Re: Kicking Camel Grill Plan Review  
174 N. McKinley St.  
Coats, NC 27521

This letter acknowledges the review for the above referenced establishment. The plan, received 5-6, and specifications are approved with the following comments:

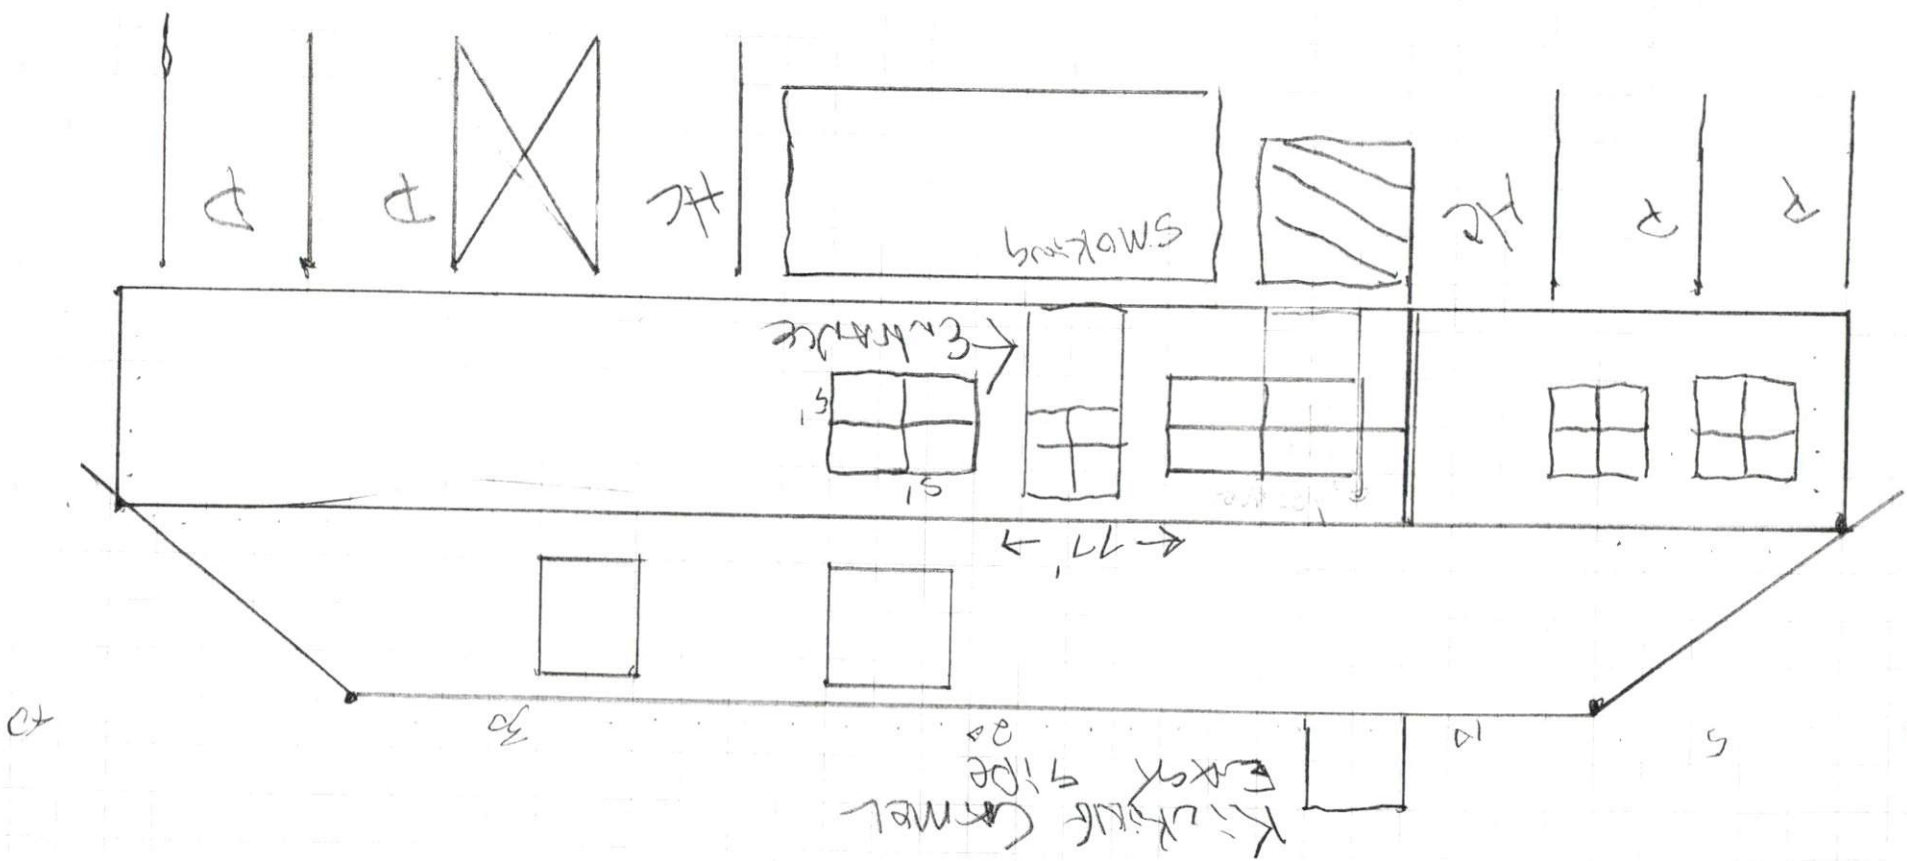
- 1- All food equipment must comply with subpart 4-205 of the North Carolina Food Code and installed as specified in Sections 4-402.11 and 4-202.12.
- 2- Lighting must comply with Sections 6-202.11 and 6-303.11 of the North Carolina Food Code.
- 3- Handwash sinks shall have splashguards.
- 4- Floors, walls, and ceilings finishes shall comply with Sections 6-101.11 and 6-201.11 of the North Carolina Food Code.
